From: Dunderdale, Chris <Chris.Dunderdale@lancashire.gov.uk>
Sent: 26 November 2018 14:48
To: Stephen Kilmartin
Cc: planning
Subject: RE: 3/2018/0914

Thank you for re-consulting the Lead Local Flood Authority (LLFA) on the above application. I have had a look through the information provided and I have the following observations to make:

The application is for the erection of 188 new dwellings including means of access and associated works. To include 57 affordable dwellings (29 affordable rent and 28 shared ownership).

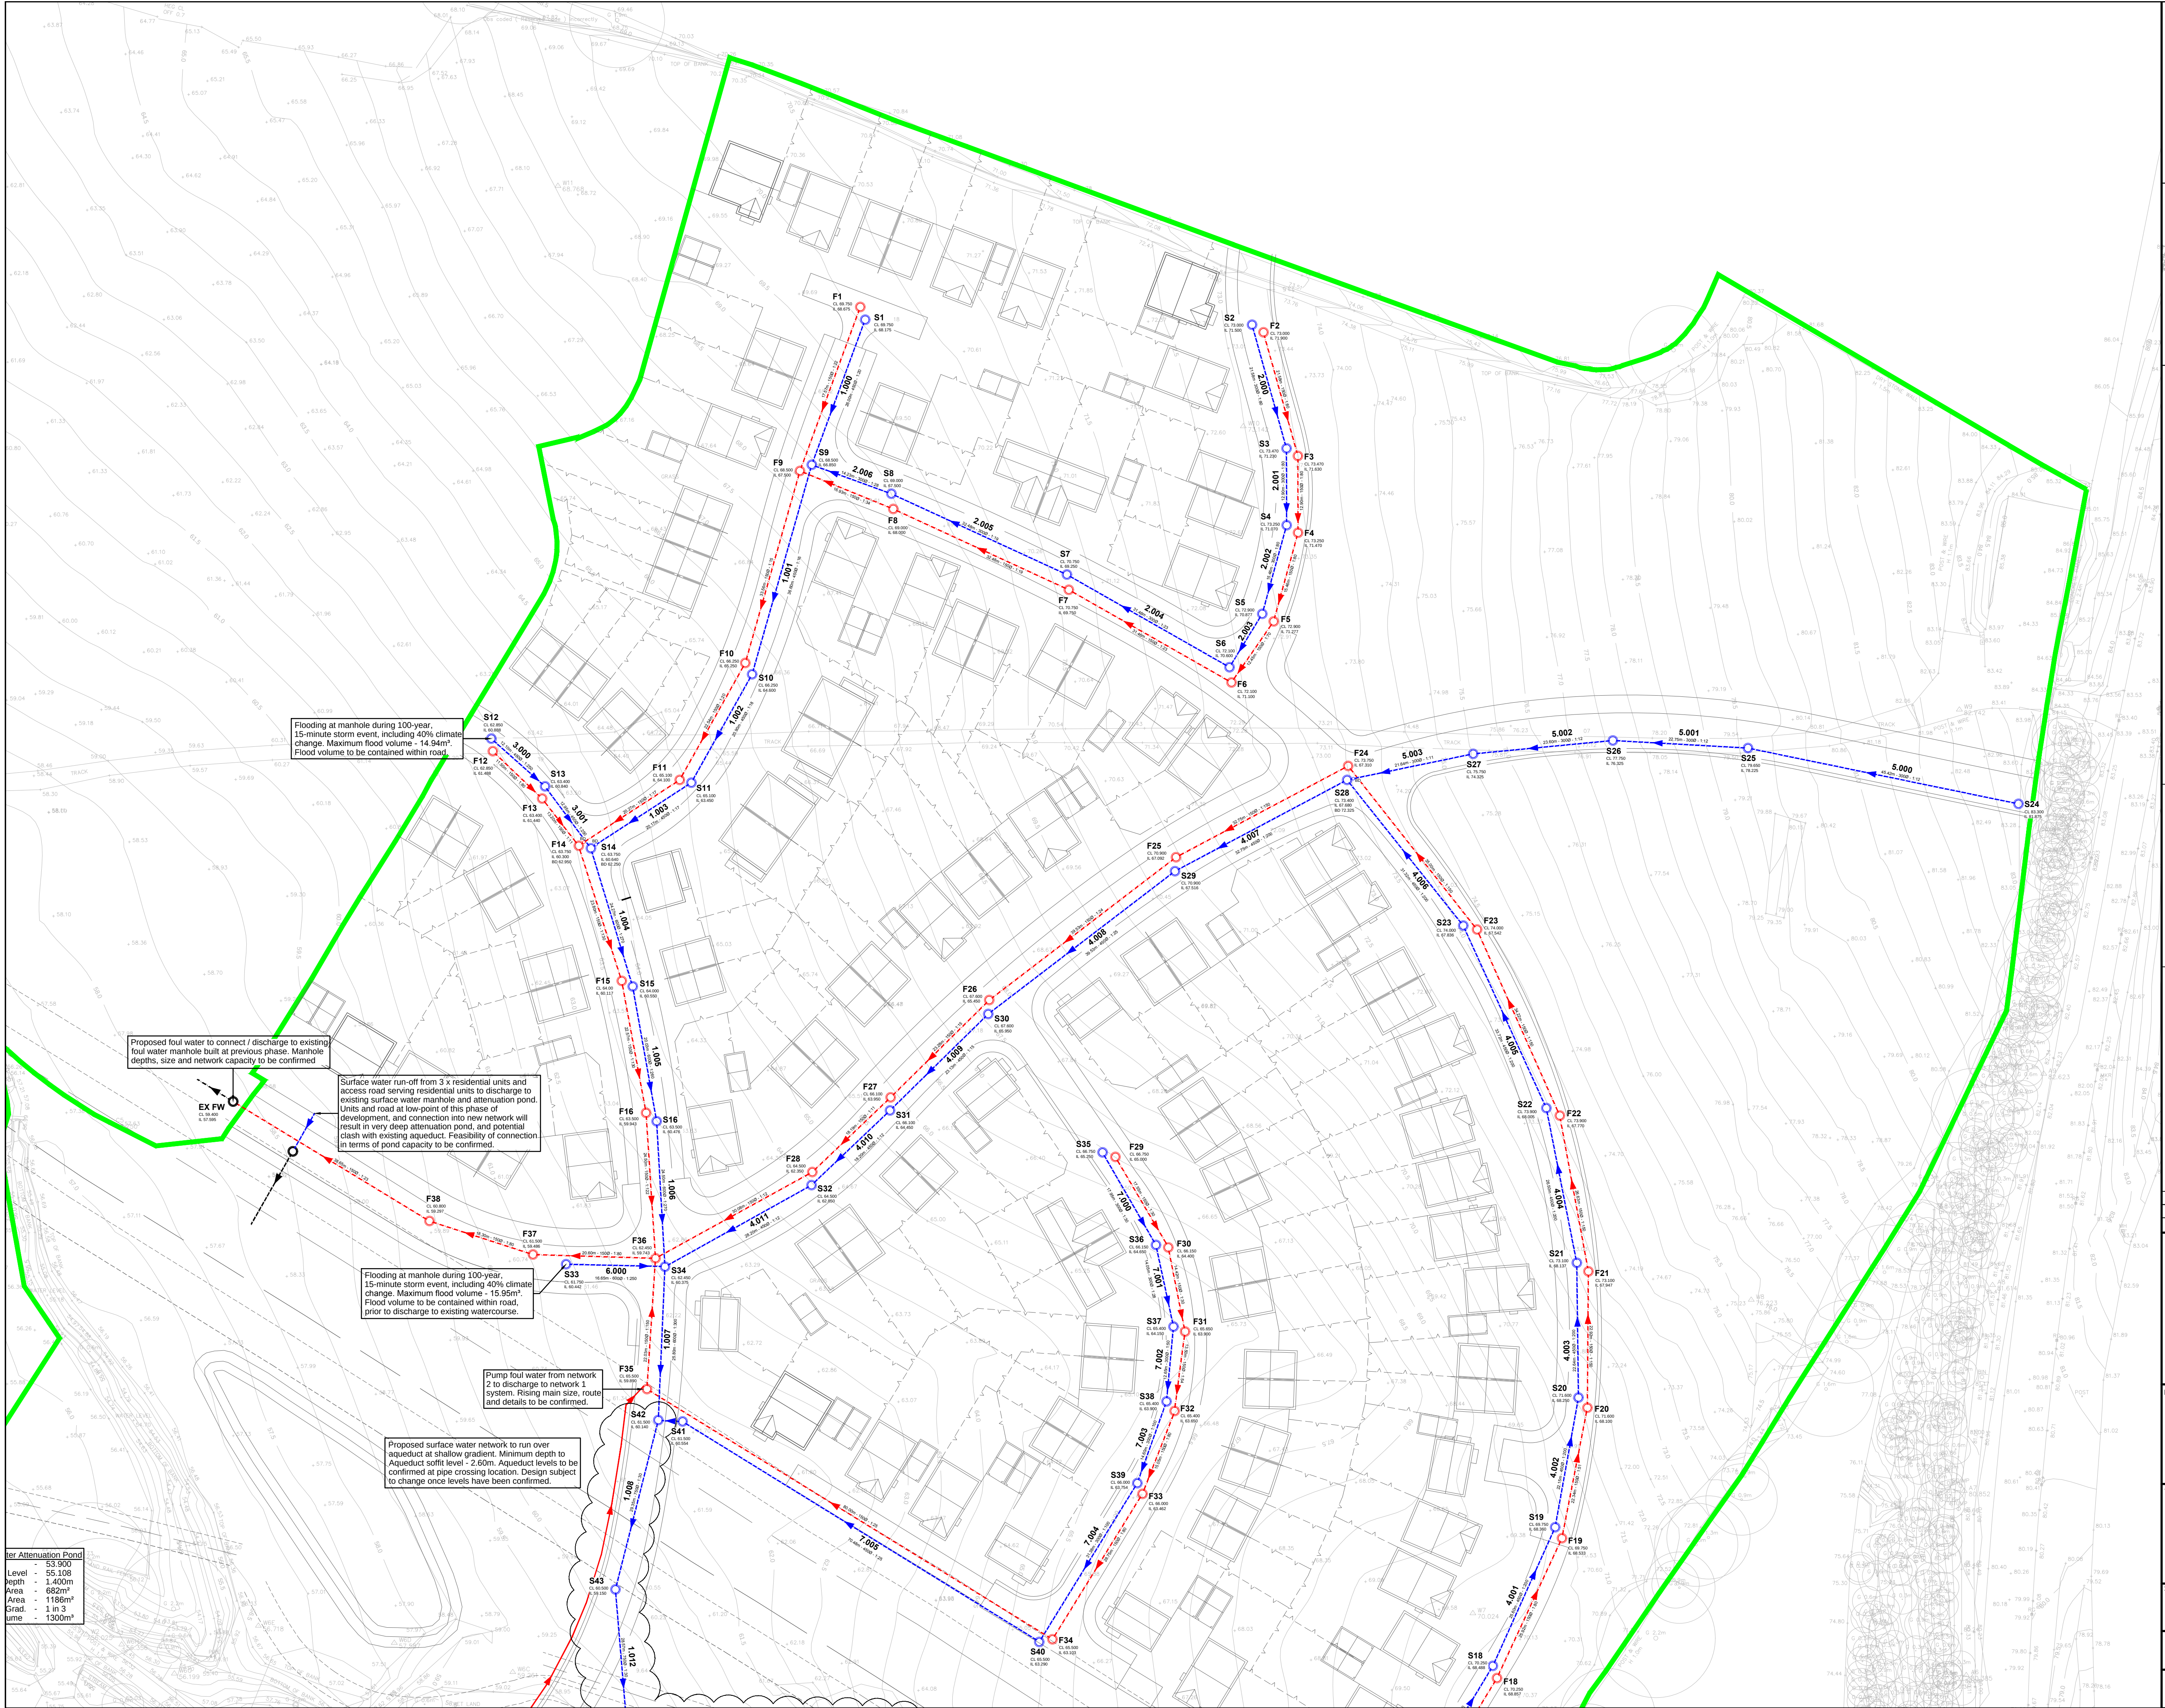
- 1) There are a number of discrepancies between the information presented on the drainage layout plan and the information presented in the supporting calculations. Please see below. Please can you bring these discrepancies to the attention of the applicant and ask for them to be checked and amended for accuracy?

- a) The surface water drainage layout plan and the supporting calculations show different invert levels for structures S34, S61, S62 and S63.
 - b) The surface water drainage layout plan and the supporting calculations show different slopes for pipes PN3.000 (network 1), PN3.001 (network 1), PN1.005 (network 1), PN1.006 (network 1), PN4.002 (network 1), PN6.000 (network 1), PN1.007 (network 1), PN1.009 (network 1), PN1.000 (network 2), PN1.001 (network 2), PN1.005 (network 2), PN1.006 (network 2), PN2.000 (network 2), PN2.001 (network 2), PN1.008 (network 2), PN1.009 (network 2) and PN1.010 (network 2).

- c) The surface water drainage layout plan and the supporting calculations show different pipe sizes for pipes PN1.007 (network 1), PN1.007 (network 2), PN1.008 (network 2), PN1.009 (network 2), PN1.010 (network 2), PN1.011 (network 2), PN1.012 (network 2), PN1.013 (network 2) and PN1.014 (network 2).

- 3) The applicant has only modelled the surface water drainage for network 1 up to the point of connection to the attenuation pond. This is insufficient as it fails to fully demonstrate the suitability of the proposed surface water drainage network. It also fails to demonstrate that surface water runoff will not exceed the pre-development runoff rate for the corresponding rainfall event. Please can you bring this to the attention of the applicant and ask for the model to be updated to also include the attenuation pond and outfall to the receiving watercourse?

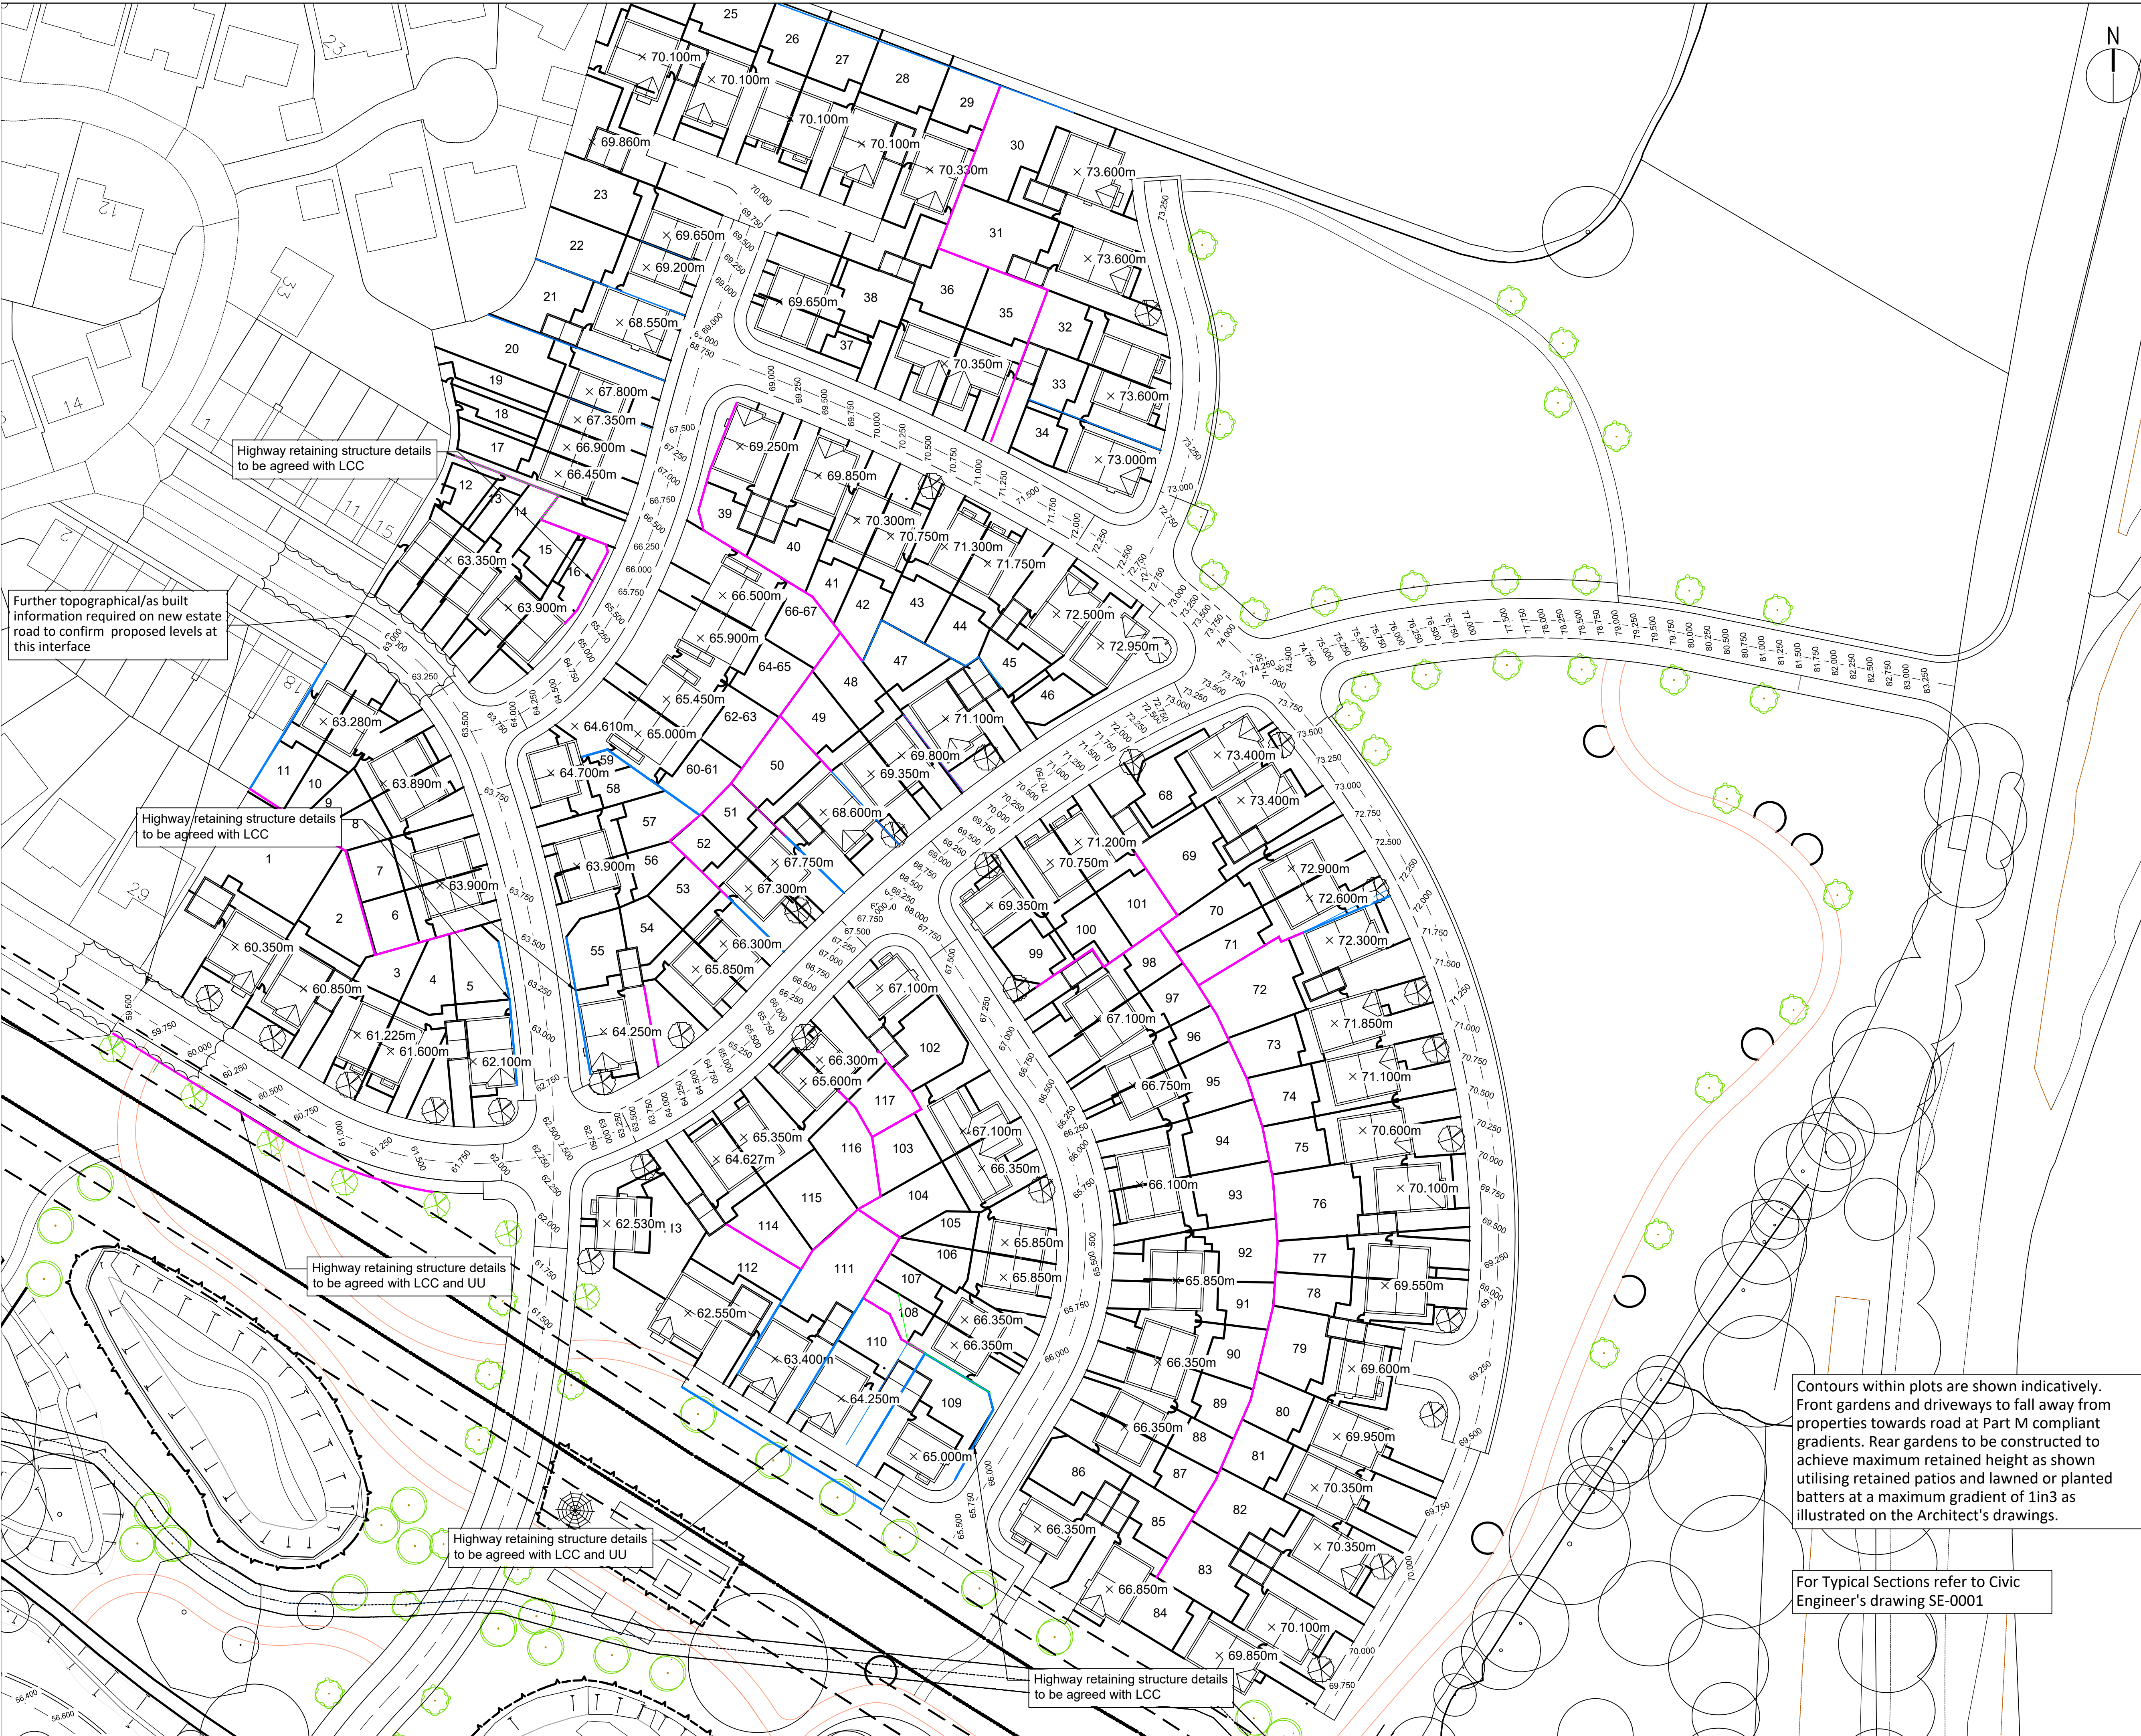
- 5) The applicant has failed to provide sufficient details relating to the intended changes in site levels across the site and the impacts that this may have on local flood risk (both on and off site). Please can you bring this to the attention of the applicant and ask for further information to be provided in this regard?
